EP/75/13 - 34 Tamarisk Way, East Preston

For the attention of Mr Sullivan
EP/75/13 – Little Thatches, 34 Tamarisk Way

TREVOR E. UNSTED LTD

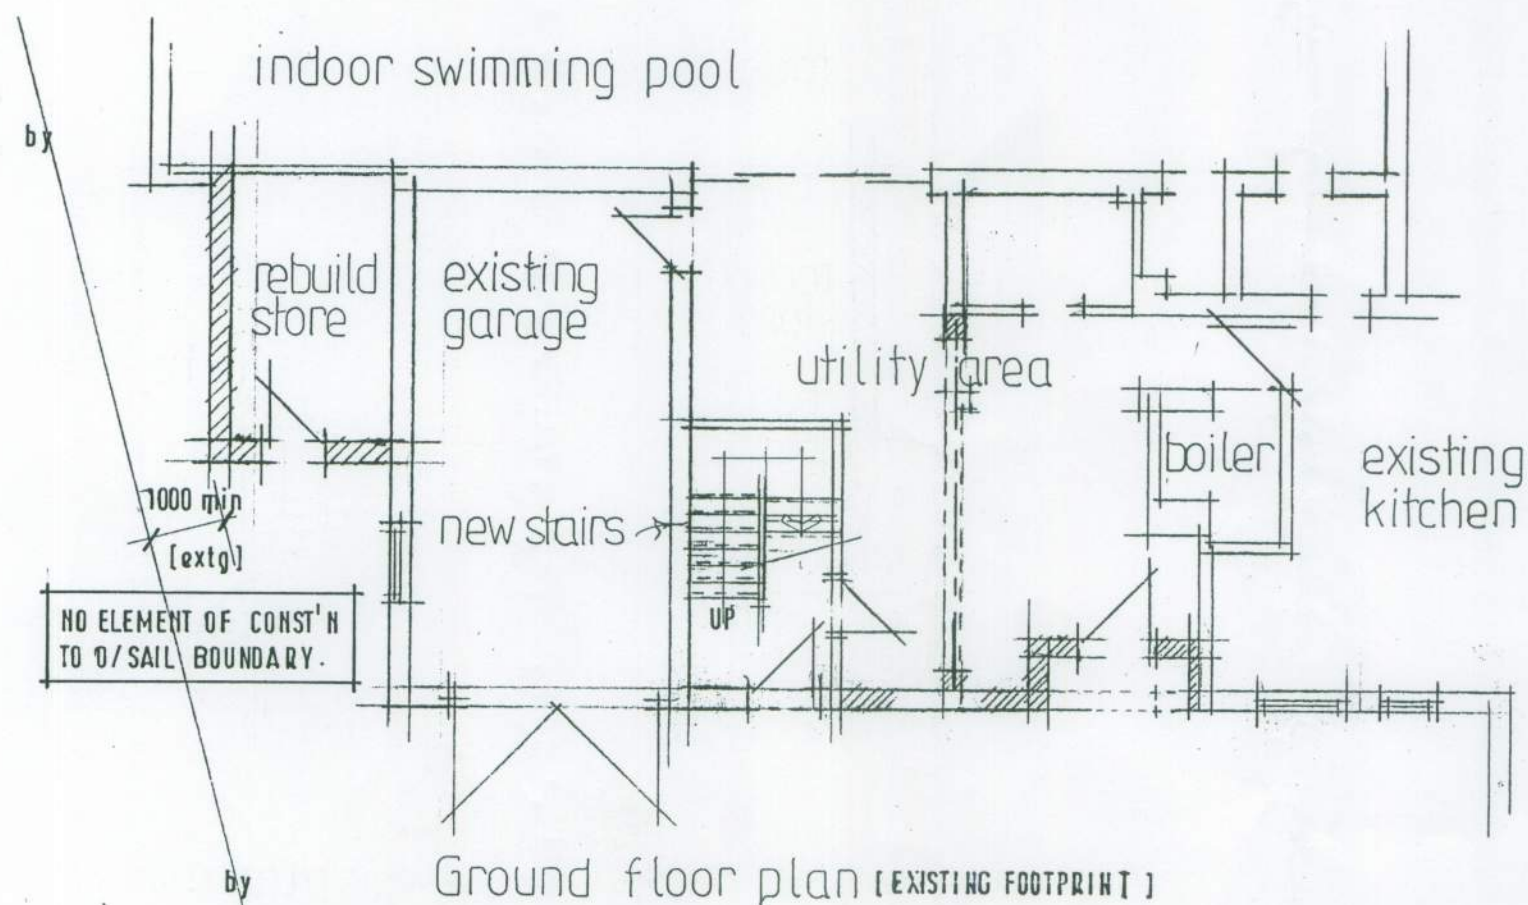
The owners of Little Thatches presently own a single storey building, the flat roof of which we can just see above our fence. This building abuts the fence and there is very little clearance between it and the fence although the plans do not indicate the dimensions of this clearance.

The application for planning approval is to add a complete storey to make it into a two storey building. The resulting development will tower above the fence, be out of scale with other buildings we can see, will prevent sun and light from the south getting into part of our garden and will deprive us of all privacy.
